RE: Bonshaw Solar Farm (SSD-9438) (Inverell Shire)

We have reviewed the Bonshaw Solar Farm Environmental Impact Statement prepared by ERM dated 18 October 2019. We have identified several issues in relation to Aboriginal cultural heritage and biodiversity. These issues are discussed in detail in **Attachment 1** to this letter. In summary we provide the following recommendations.

Attachment 1: Detailed BCD Comments – Bonshaw Solar Farm (SSD-9438)

Figure 1: TD-OS14 'Site Extent' (source AHIMS site card / Ozark Heritage 2011).

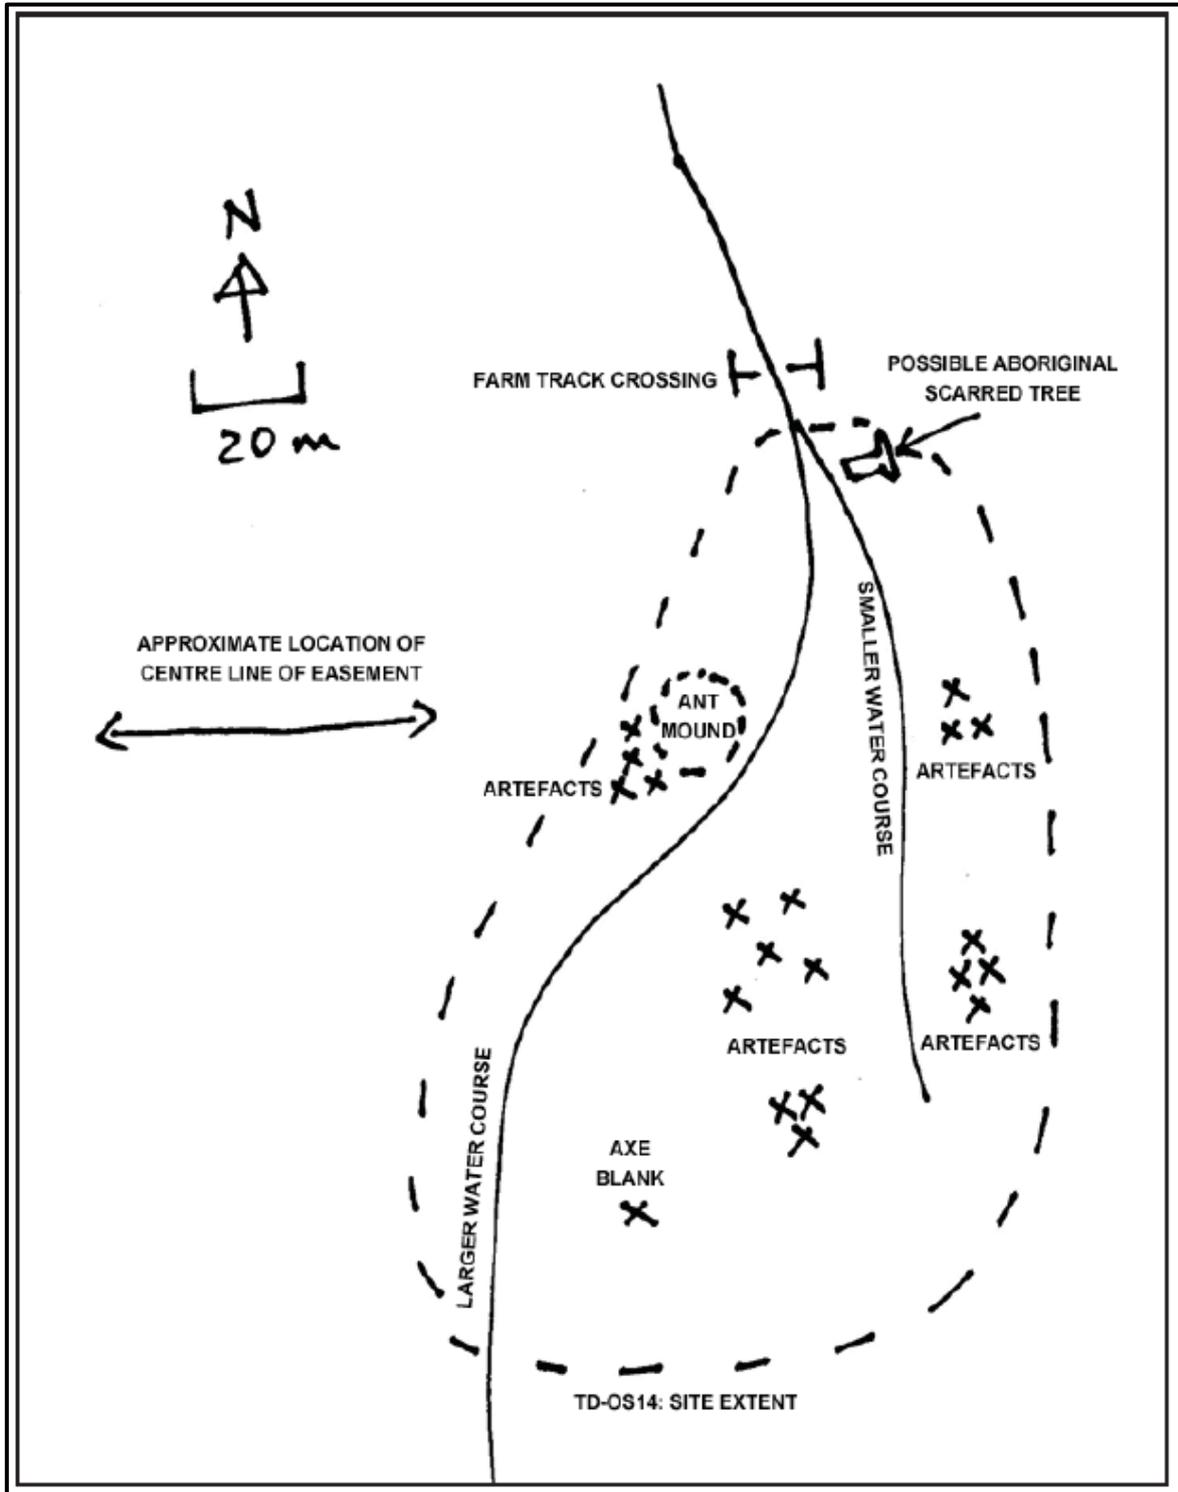
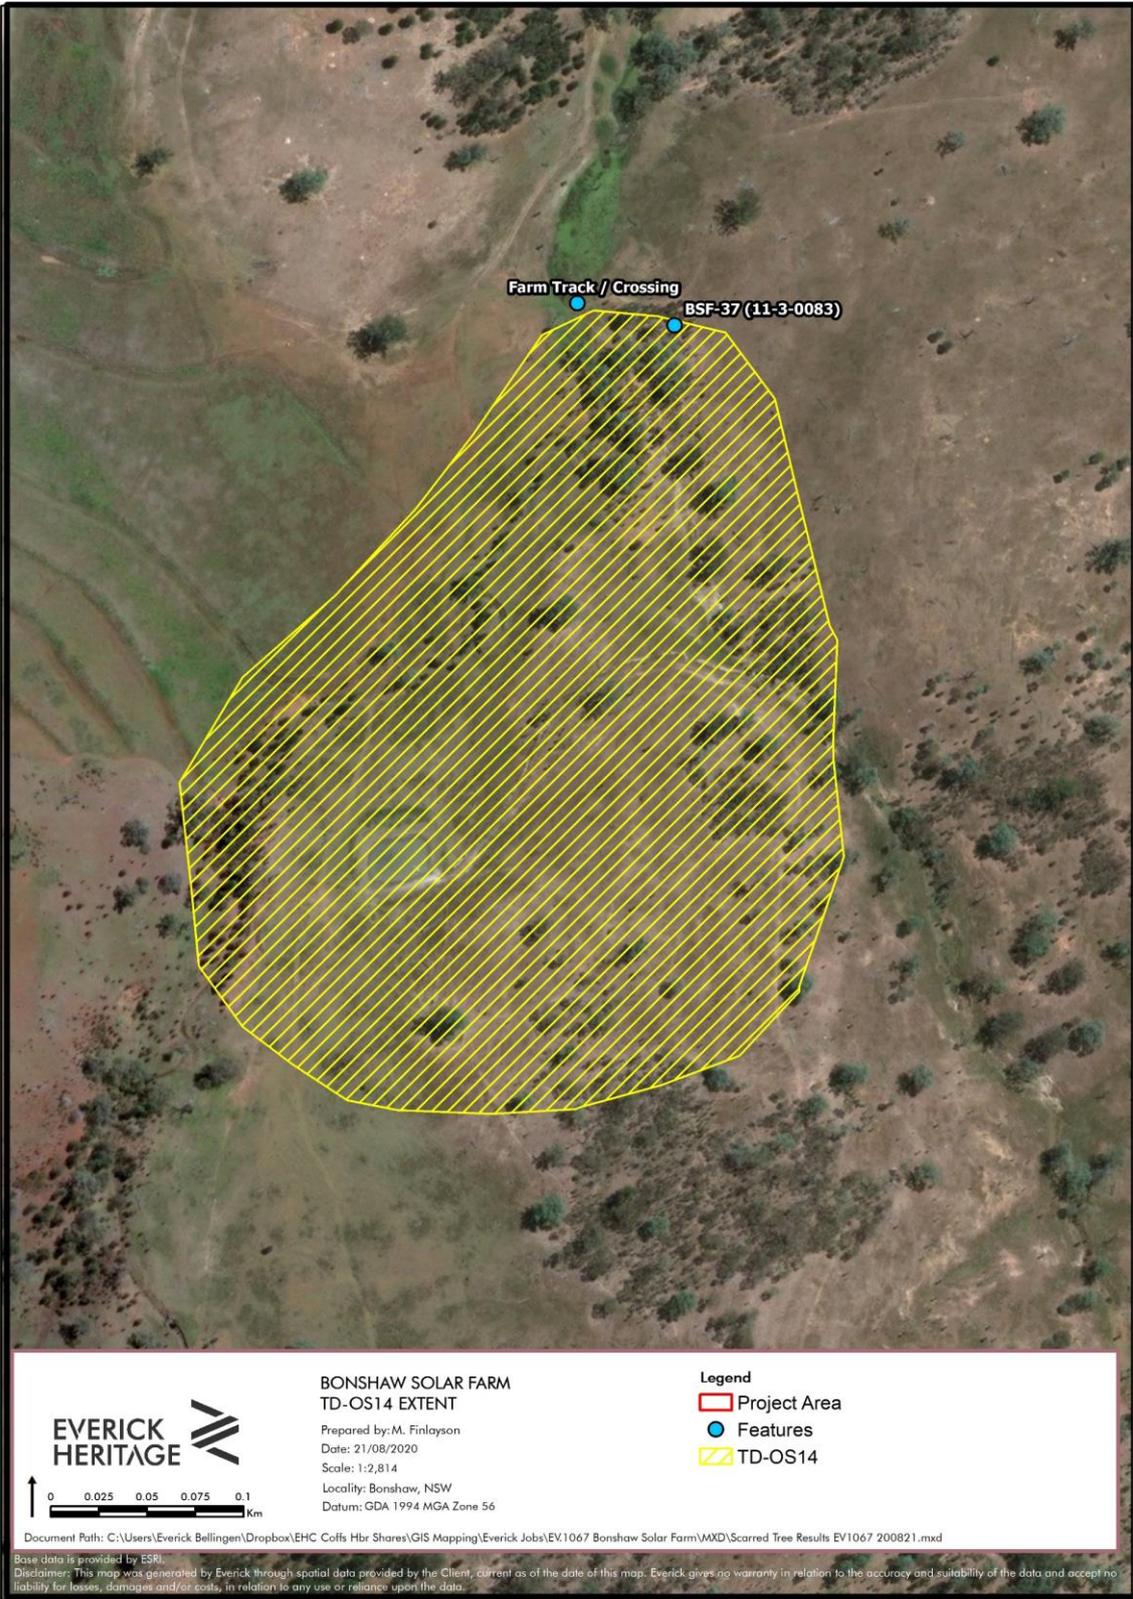
We also note the comments provided in the ACHAR regarding the attempted rediscovery of AHIMS registered site 11-3-0083. BCD notes that the directions for finding the site, as recorded on the AHIMS site recording form, are very clear being, *"Approximately 3 km along Bruxner from Beardy River crossing located on the access track from the Bumaresq (sic) Switching station to structure W5 between structures 3 and 4."*

Although it appears the scale on the site map included in AHIMS maybe wrong, the map itself, along with the written description of the site location should make rediscovery possible. Given the fact that 11-3-0083 likely represents an extension of the hypothesised occupation complex and contains not only stone artefacts but also an Aboriginal scar tree, we recommend that further attempts, using all the information available, to rediscover AHIMS 11-3-0083 should be made. It is very likely that AHIMS 11-3-0083 represents a further extension of any occupational complex that may be present within the project area and is located in an area identified for impact by the proposed works.

Further assessment of the site should include a concerted effort to rediscover the previously recorded AHIMS 11-3-0083 which we consider highly important to the contextual understanding of the Aboriginal Cultural Heritage (ACH) value of the project area.
